Alex Avenue Public School (SSD-9368)
Response to Submissions

ATTACHMENT 1 – KEY ISSUES

ATTACHMENT 2 – OTHER MATTERS

## EXISTING SITE PLAN

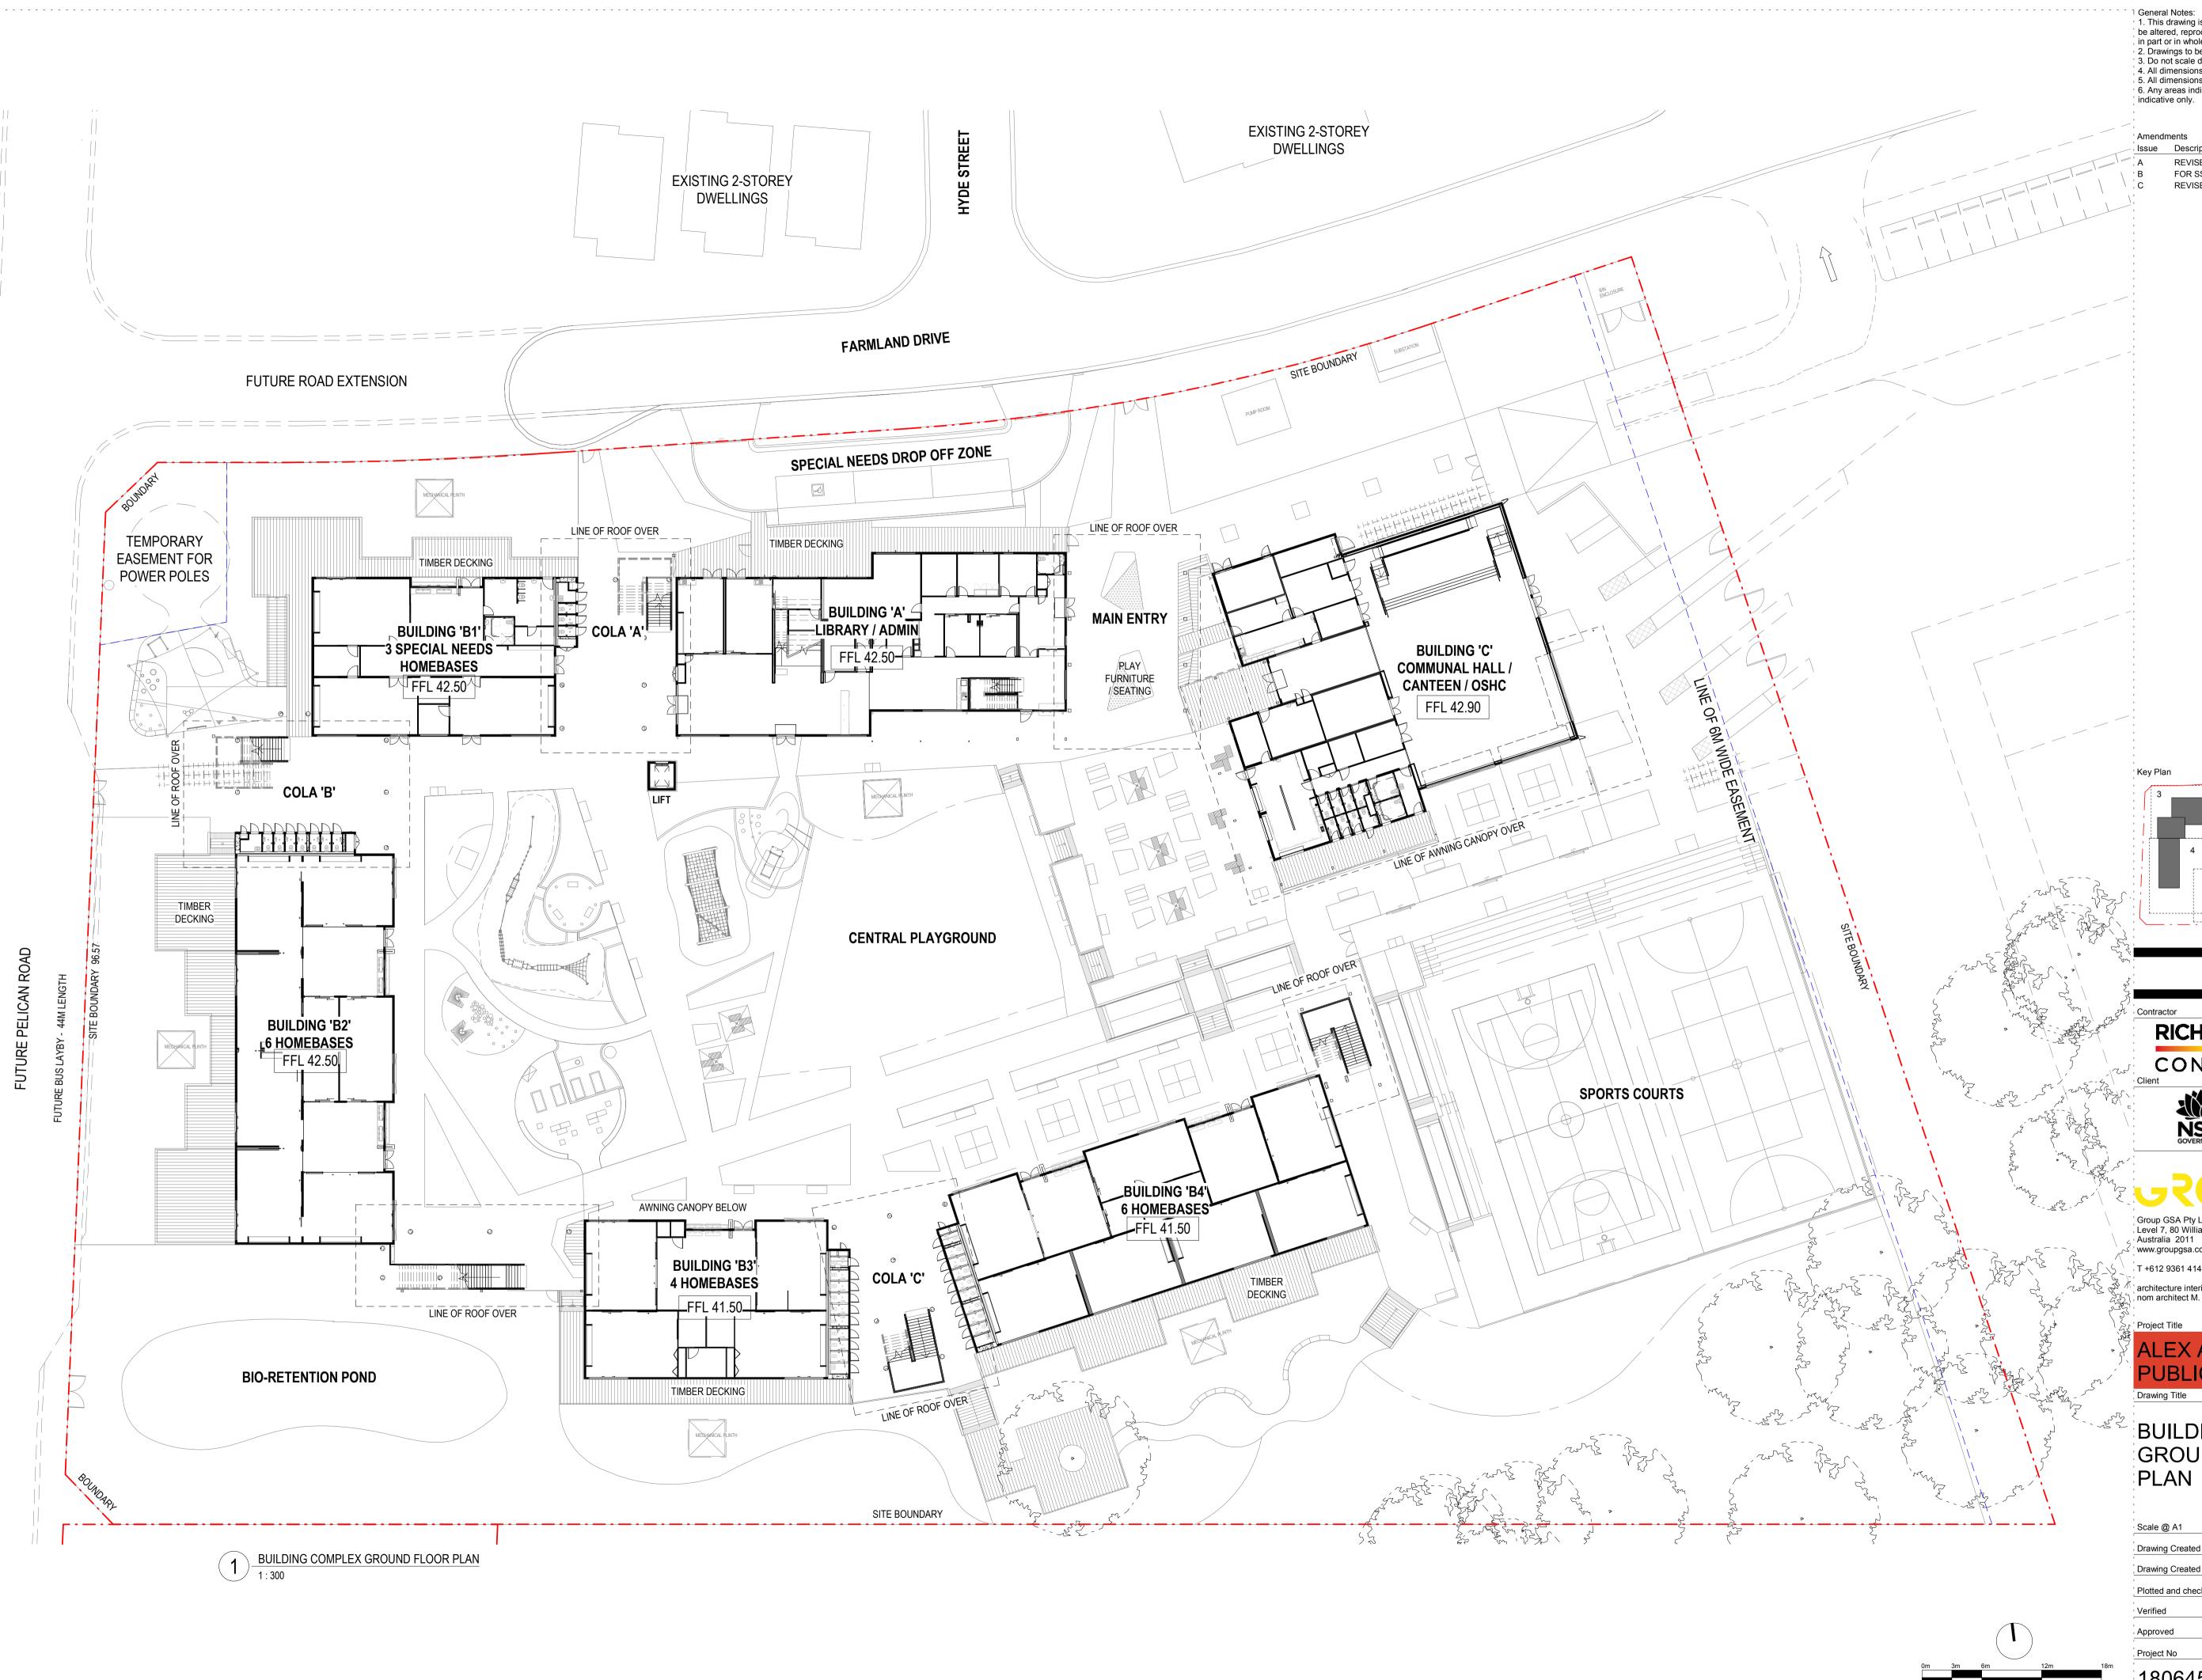
3. The Environmental Impact Statement (EIS) included an Options Analysis with three designs, including two options which provided the main entrance to the future Pelican Road and the third option providing the main entrance from Farmland Drive.

Farmland Drive is a local road which is approximately 9m wide and has no pedestrian or cycling facilities within the road reserve. The Department considers Farmland Drive an inappropriate main frontage to the site given the classification of the road and lack of supporting infrastructure to assist with accessing the site. The Department considers that the main frontage to the school should be designed to facilitate the long-term functioning of the school (not the short-term) and should be redesigned to address the future Pelican Road, which has been identified as a major road under the Alex Avenue Precinct Plan. A staged approach to operation may be considered to reflect the timing of delivery for Pelican Road

## **BUILDING COMPLEX** GROUND FLOOR

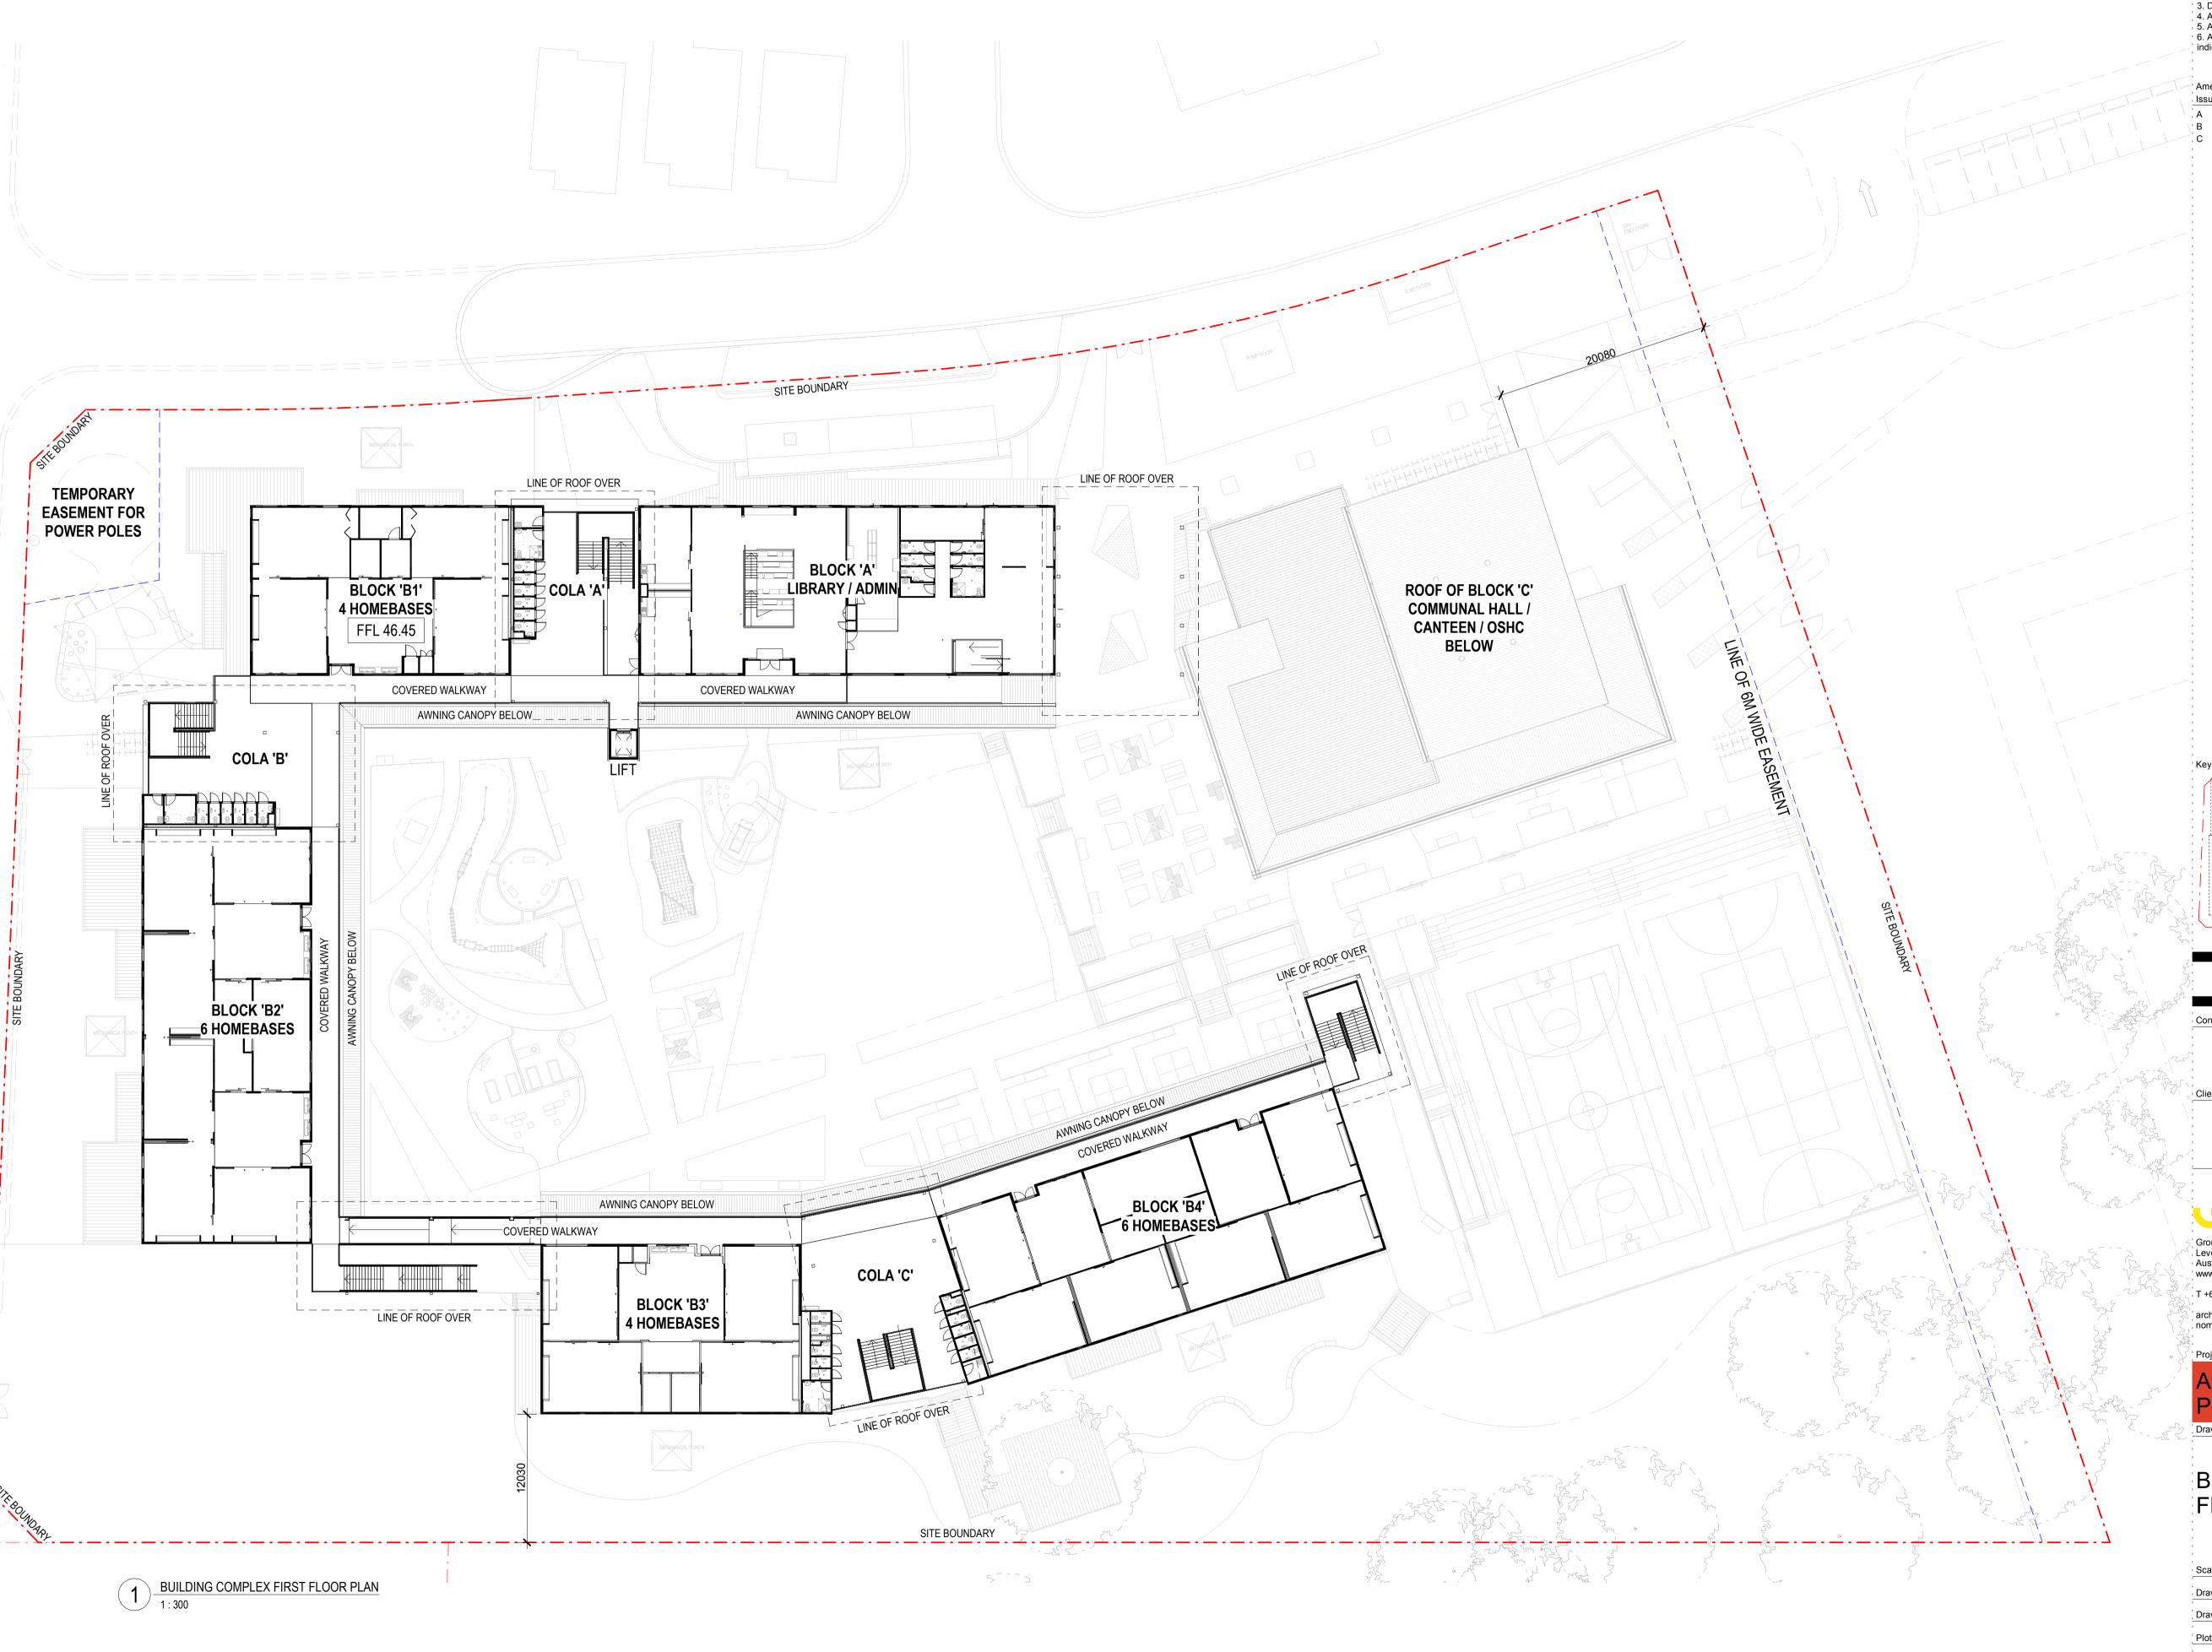
1. The EIS and associated documentation refer to an historic Lot and DP. All relevant documentation, including the application form, must be updated to reflect the correct Lot and DP and submitted to the Department. Details of the adjoining land should also reflect current cadastre.
2. The proposed layout of the school has not taken into consideration the 6m wide easement for access and services located along the eastern boundary of the site in favour of the adjoining land. The layout of the school must be redesigned taking into consideration the right of access over the subject site.

4. The design outcomes outlined within the Urban Design Report is entirely inconsistent with the design proposal reviewed by the State Design Review Panel (SDRP) and cannot be supported. The current proposal presents large areas of monolithic blank façades of undefined materiality to the public domain, without contribution to the streetscape and without a positive impact on the quality and character of the neighbourhood.

The proposal has been stripped of all design quality, lacking in articulation, detail, sophisticated materiality and aesthetic appeal. The original proposal of pavilion forms in a landscape setting has been replaced by forms of undifferentiated scale with little indication of how landscaping is integrated into the project.
